**WEST SUSSEX COUNTY COUNCIL
STRATEGIC PLANNING CONSULTATION**

SUBJECT: LU-17-364

No. 2-13, Duke Street, Littlehampton, BN17 6EY

Retention and conversion of former public house building and the erection of a two storey block to provide a total of 9 residential units with associated parking. Re-submission of planning application LU/117/17/PL

Drawing
Proposed Layouts

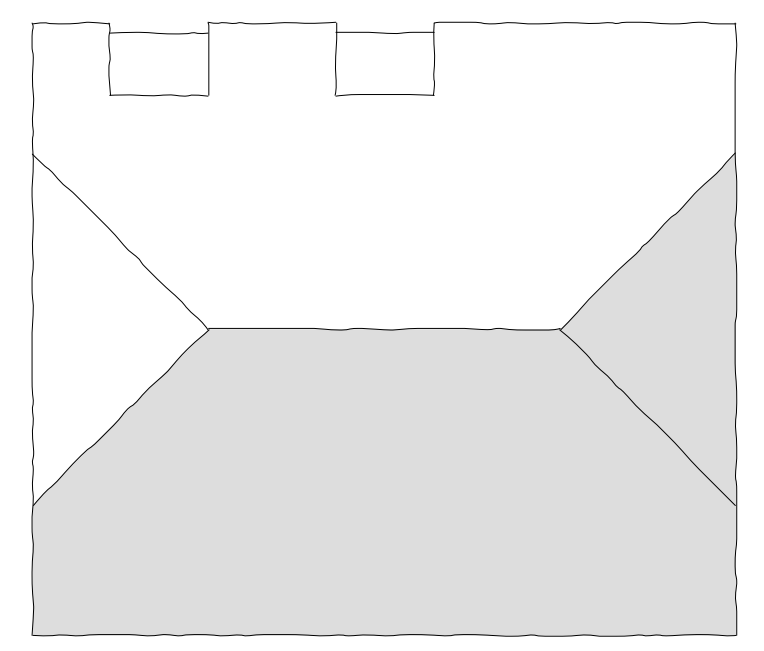
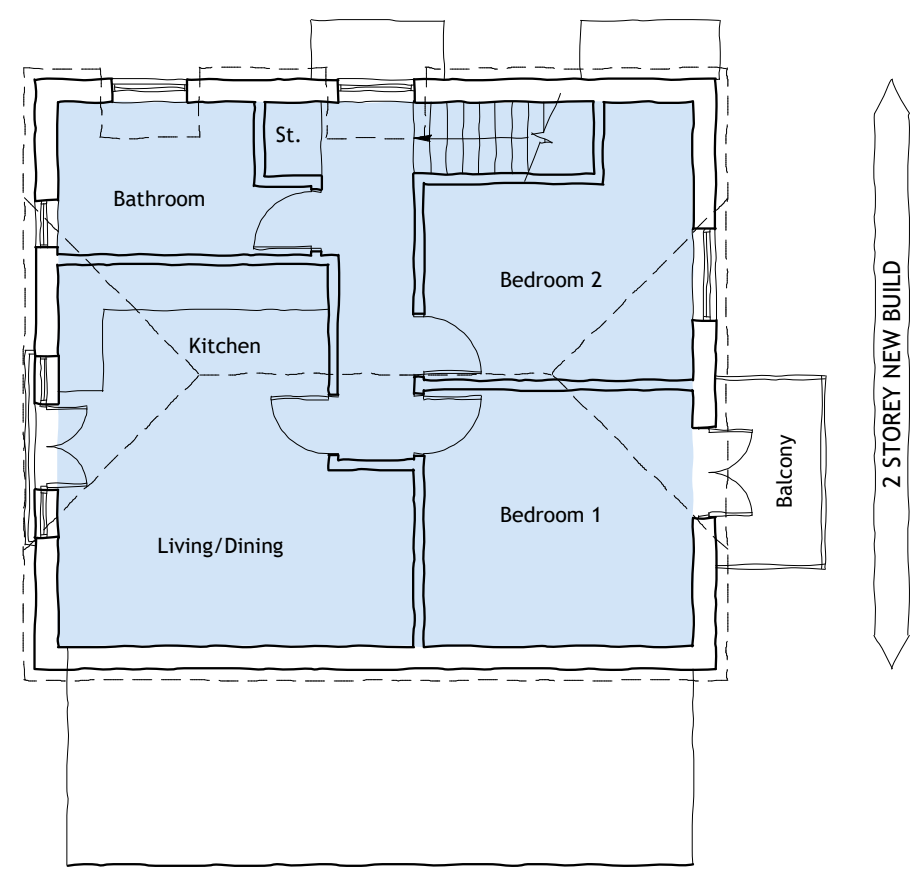
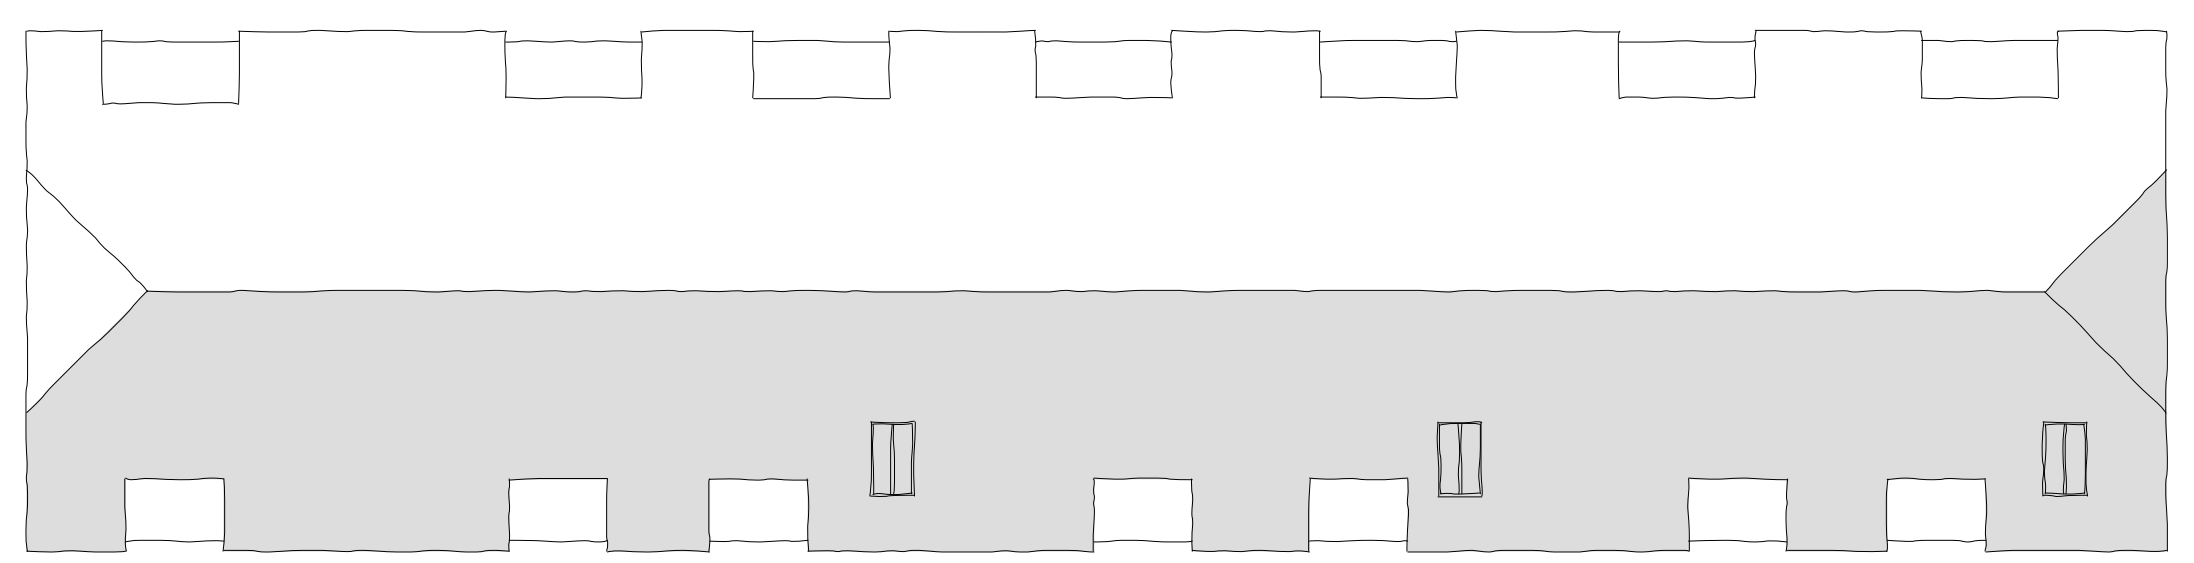
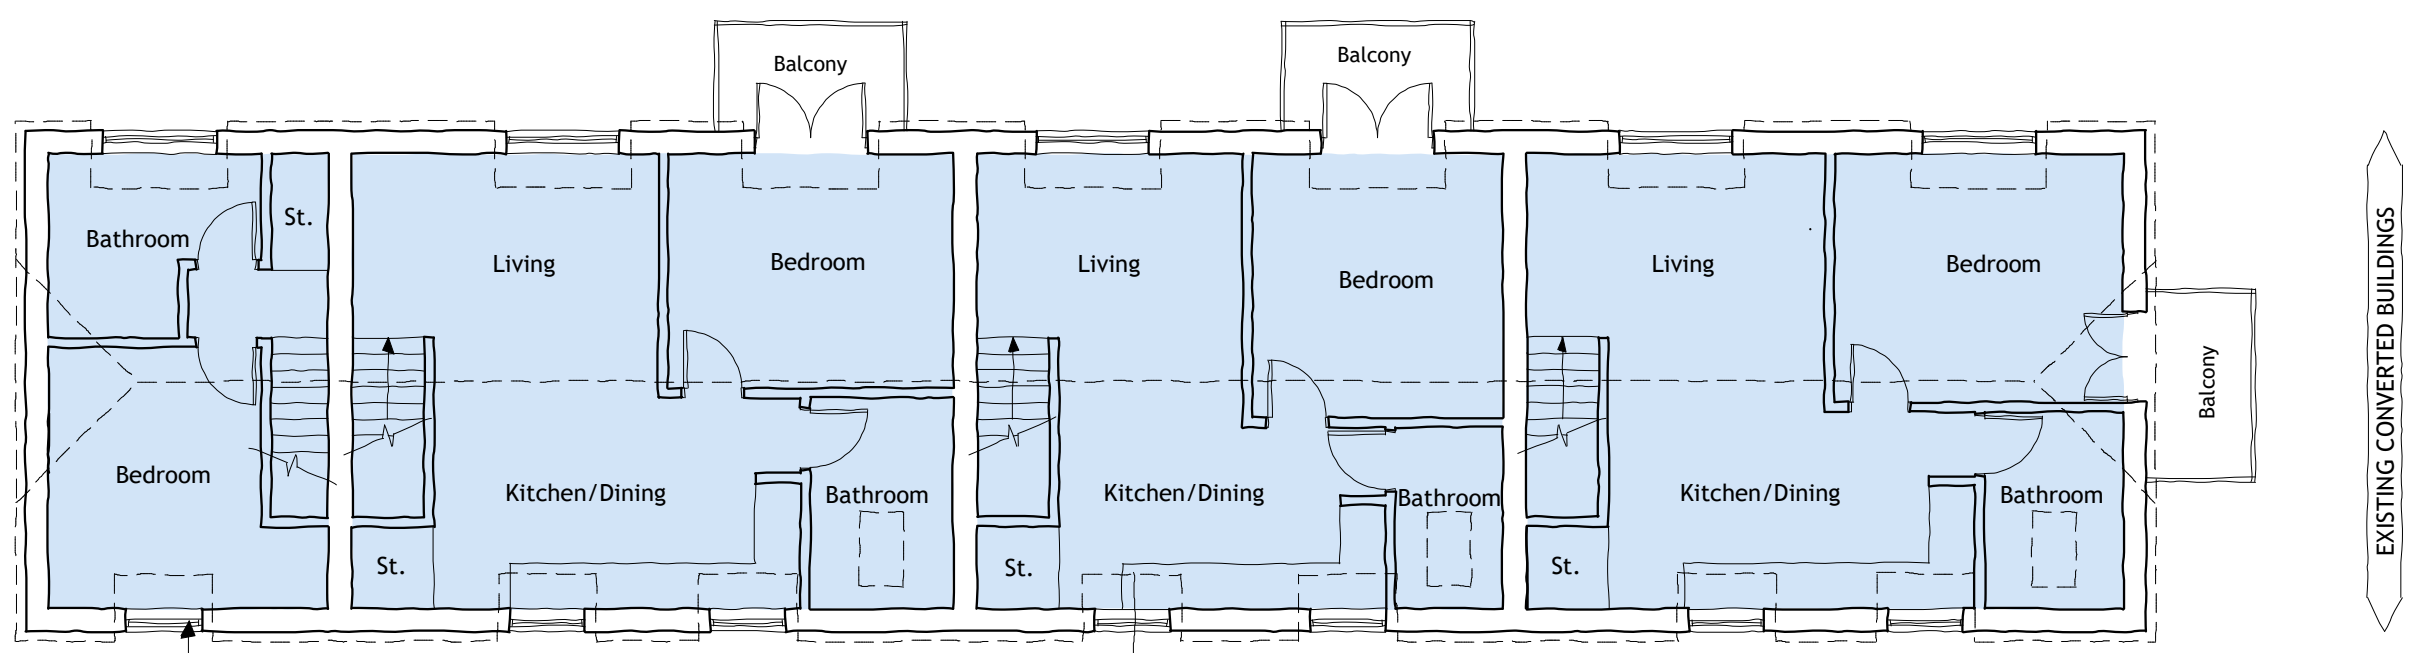
The new proposals will provide 9 dwellings, consisting of 7 x 1 bed flats/maisonettes and 2 x 2 bed flats with 4 car parking spaces allocated. These are within the maximum standards set out by WSCC and will give at least 1 space for every two flats. It is not clear if these spaces will be allocated or unallocated however due to the location in the town centre management of these spaces will be required to ensure the parking can be controlled. There are plenty of car parks within the vicinity should additional parking be required however given it is in a very sustainable location and close to bus and rail links; the flats are likely to encourage people who don't need parking.

Secure covered cycle storage should be provided within the development in line with current guidance for cycle storage in flats of half a space for each (1/2 bed flat) which would equate to 4 to 5 spaces in total.

No part of the development shall be first occupied until covered and secure cycle parking spaces have been provided in accordance with plans and details submitted to and approved by the Local Planning Authority.

No part of the development shall be first occupied until the car parking has been constructed in accordance with the approved site plan. These spaces shall thereafter be retained at all times for their designated purpose.
